Recommendation Report for Planning Permission for Works or Extension to a Dwelling

REF NO: R/180/18/HH

LOCATION: 17 Kirdford Close
Rustington
BN16 2LW

PROPOSAL: Single storey rear extension.

PROPOSED
GROUND FLOOR PLAN,
ELEVATIONS & ROOF
PLAN

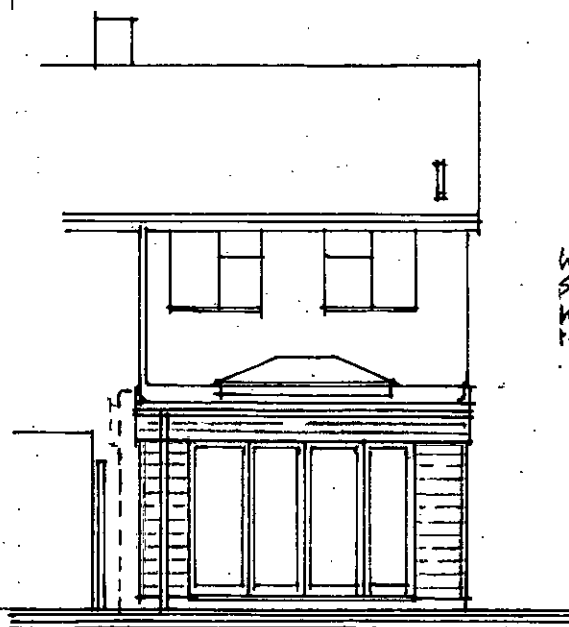
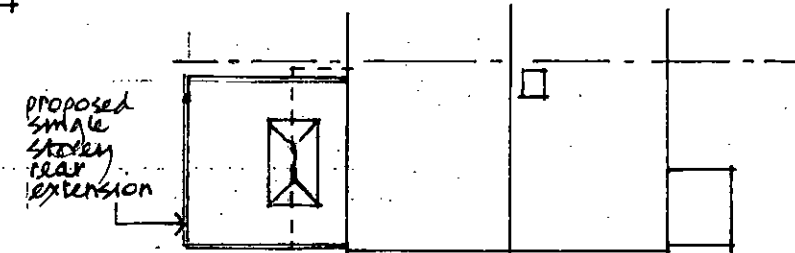
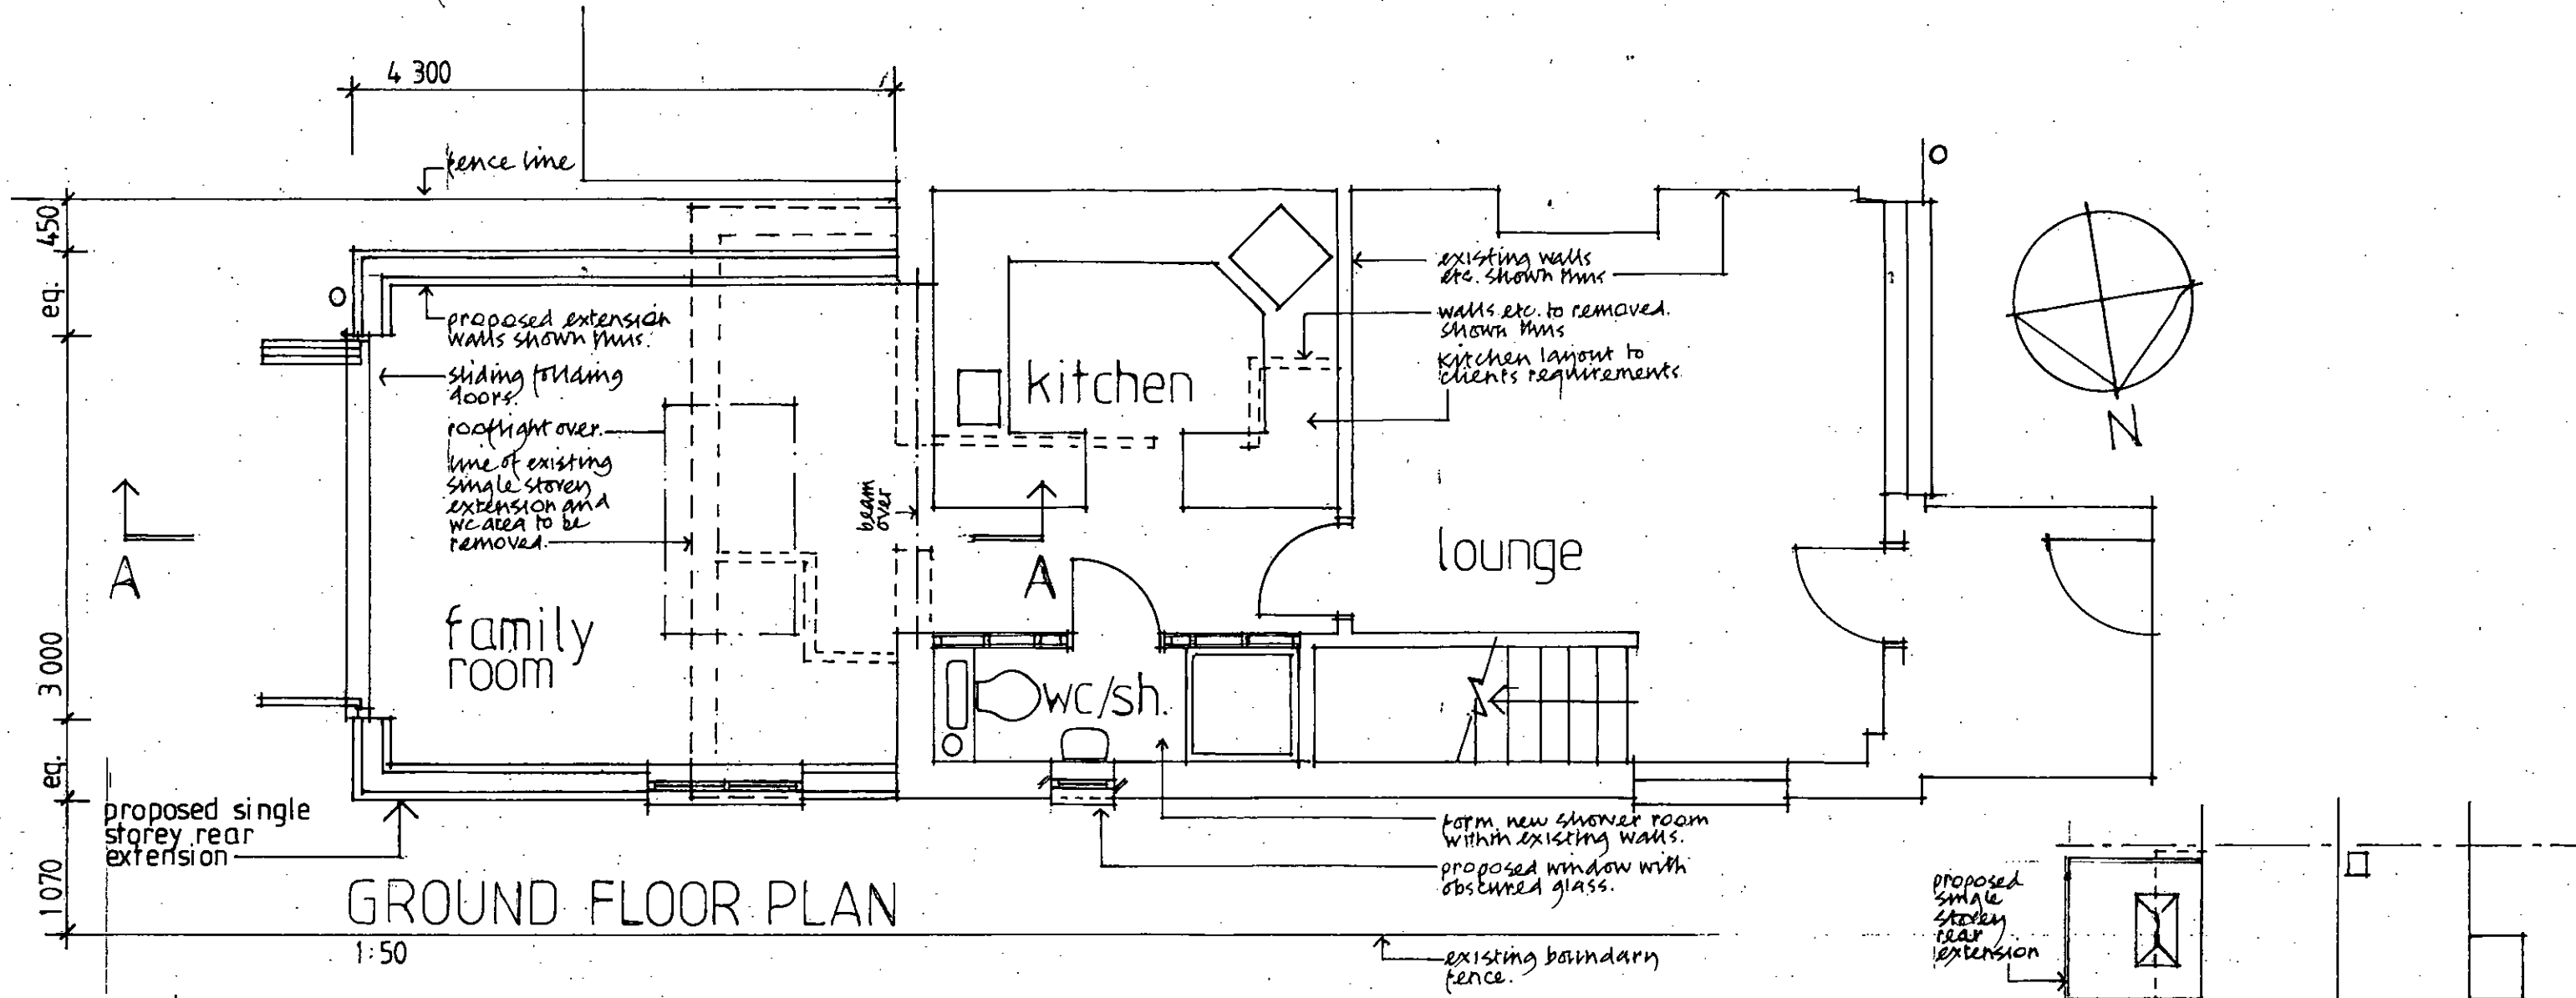
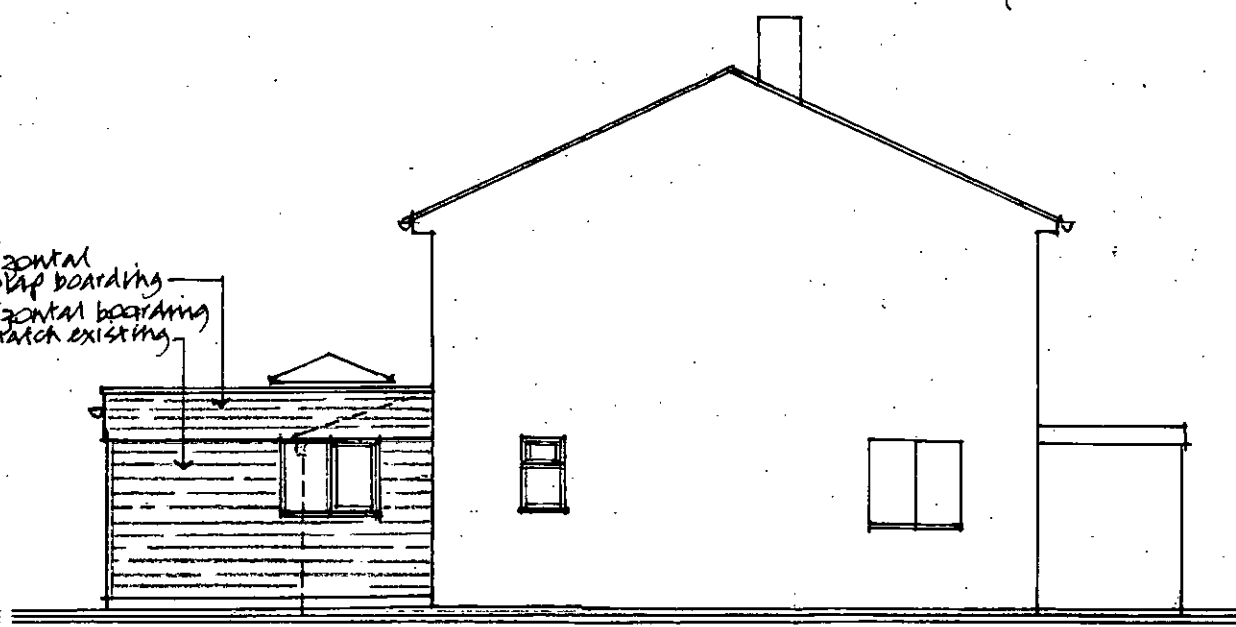
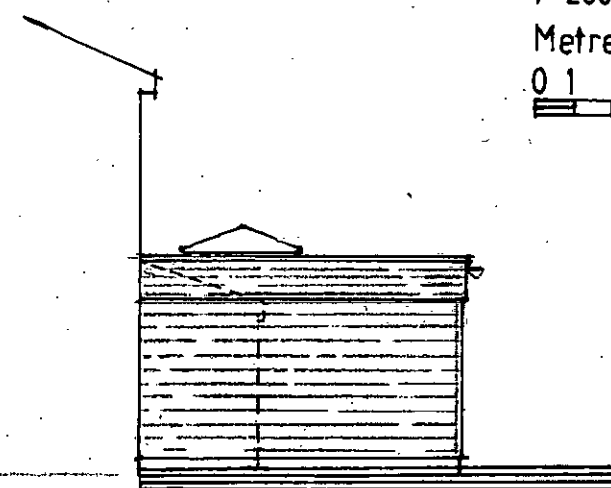
The maximum height of the proposal is 3.4m from ground level, however, this is as a result of a roof lantern, the majority of the proposal is 2.9m from ground level. This is 4.2m lower than the existing ridge height of the host dwelling. Therefore, the proposed development is considered to appear subservient, nor is it deemed to harm its established character.

The proposals maximum height is 3.4m, however, this is atop of a rooflight, which is set 1m away from the Northern, and Southern sides of the extension, the majority of the extension is 4.2m lower than the existing ridge height of the dwelling, and this is not deemed to give rise to any significant adverse impact on neighbouring residential amenity. The majority of the proposed development is the same height as the existing rear projection at the site.

Whilst due to the fact that the proposed development features a window on its Northern elevation, there is not considered to be a significant loss of privacy, as views would be impeded by the fencing that lies between the two properties.
